KITTITAS COUNTY

MEMORANDUM

TO: All Staff
FROM: Public Works Plan Review Team
DATE: February 12, 2026- UPDATE March 20, 2026- UPDATE April 6, 2026
SUBJECT: BL-26-00001 Fields

RECORD OF SURVEY

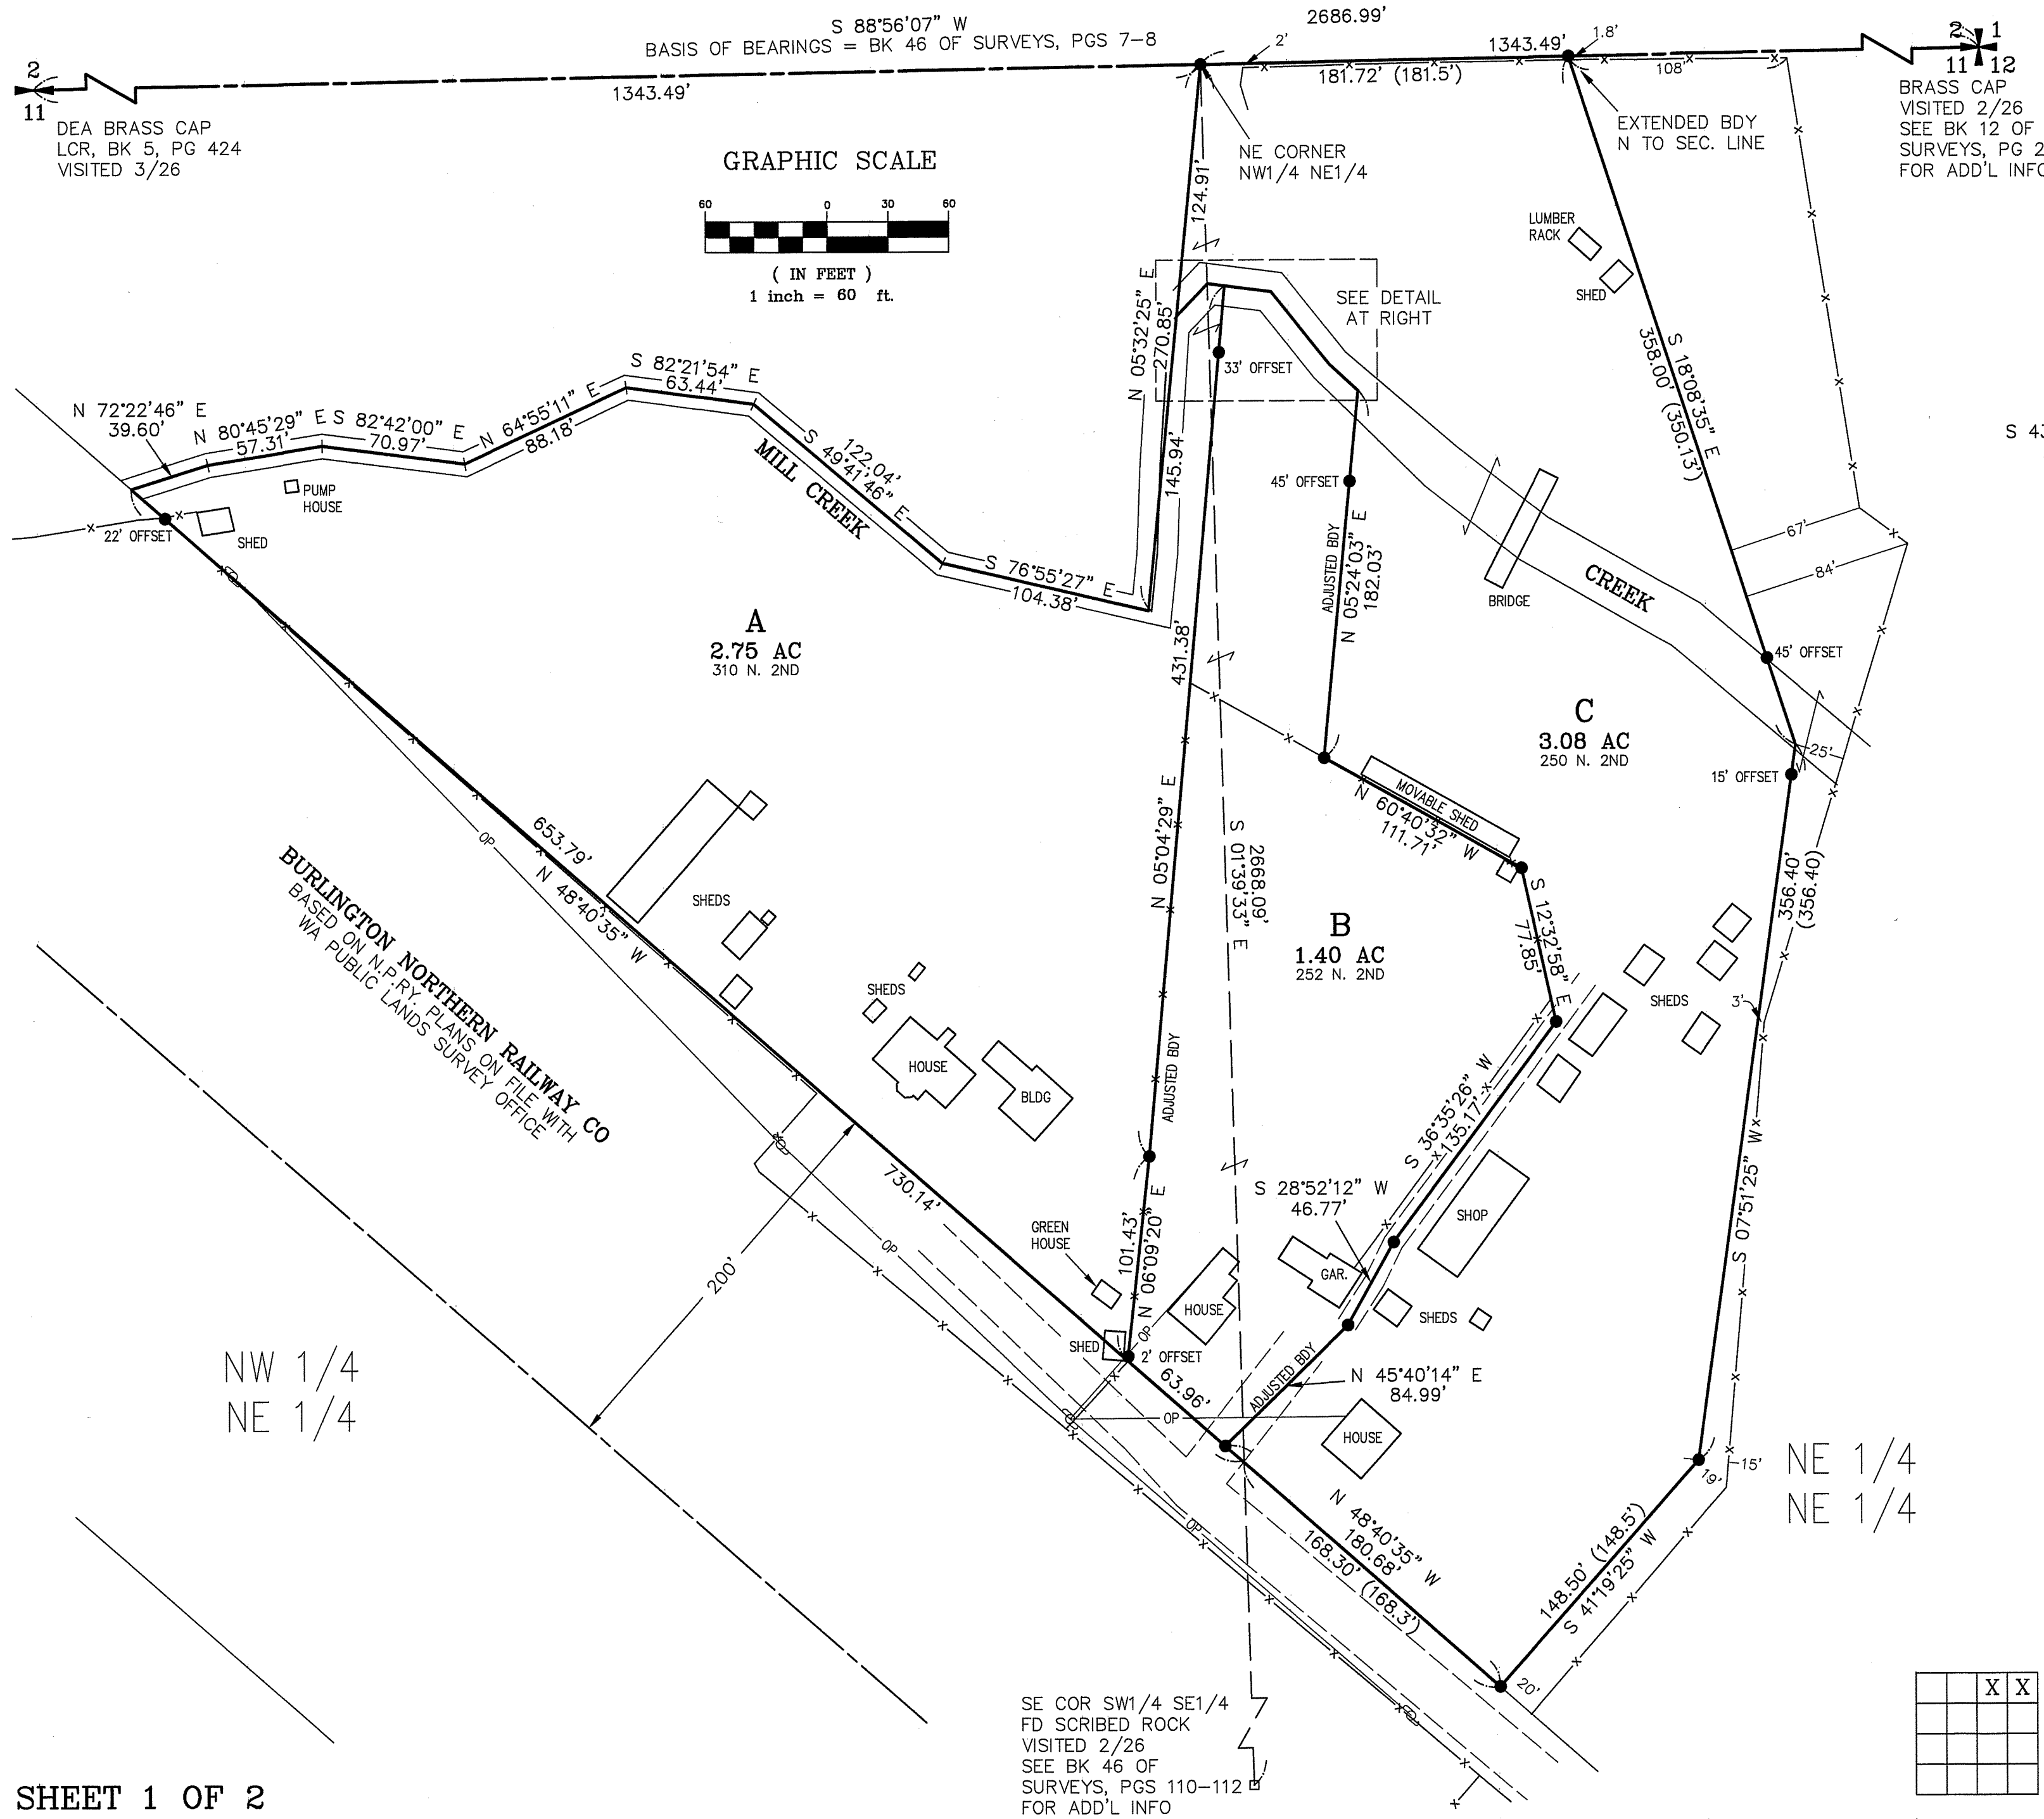
ACCESS	<ol style="list-style-type: none"> 1. An approved access permit shall be required from the Kittitas County Department of Public Works prior to creating any new driveway access or altering an existing access. 2. Maintenance of driveway approaches shall be the responsibility of the owner whose property they serve. The County will not maintain accesses. 3. Any further subdivision or lots to be served by proposed access may result in further access requirements. See Kittitas County Road Standards. 4. Provide proof of easement for shared driveway access to lots prior to final approval. <p>In addition to the above-mentioned conditions, all applicable Kittitas County Road Standards apply to this proposal. Access is not guaranteed to any existing or created parcel on this application UPDATE April 6, 2026- all comments have been met.</p> <p>OF NOTE: Parcel 745933 to retain address 310 N 2nd St ; It is unclear which home will retain 250 and 252 N 2nd St on parcel 685933.</p>

ENGINEERING	<p>Except as exempted in KCC 14.05.060, no grading or filling upon a site involving more than one hundred (100) cubic yards shall be performed without a grading permit from the County Engineer or Public Works designee (KCC 14.05.050). An application for grading in excess of five hundred (500) cubic yards shall be accompanied by an engineered grading plan (KCC 14.05.080). (CBP)</p>
SURVEY	<p>As the application does not contain a survey map, comments are herein reserved until final. (JT)</p> <p>UPDATE 03/16/2026</p> <ol style="list-style-type: none"> 1. Please show previous boundaries. Dimensions are not required. 2. Please label 2nd street as "2nd Street (County R/W-Gravel)" or similar. Identifying R/W width is not required. 3. Please identify "End of County Road" at the Gate located near the shared corner of Lots A and B.

<p>4. For Lot A driveway within the railroad right of way, please note railroad licence, agreement OR note "access by prescription".</p> <p>5. Per WAC update, legal descriptions must include legal description AND document sourced from. Please include reference to Title Report, Deeds, or Records of Survey that the legal descriptions were obtained from. (JT)</p> <p>Update 03/20/2026 All prior survey comments have been addressed on the most recent submittal. (JT)</p>
TRANSPORTATION CONCURRENCY	No transportation concurrency management application is required for this project as described.
FLOOD	Parcels 675933, 685933, and 745933 are completely within the FEMA mapped special flood hazard area (1 percent annual chance flood zone). All development within the special flood hazard area requires a floodplain development permit, including structures that are exempt from a building permit, and must follow the guidelines within KCC 14.08. (SC)
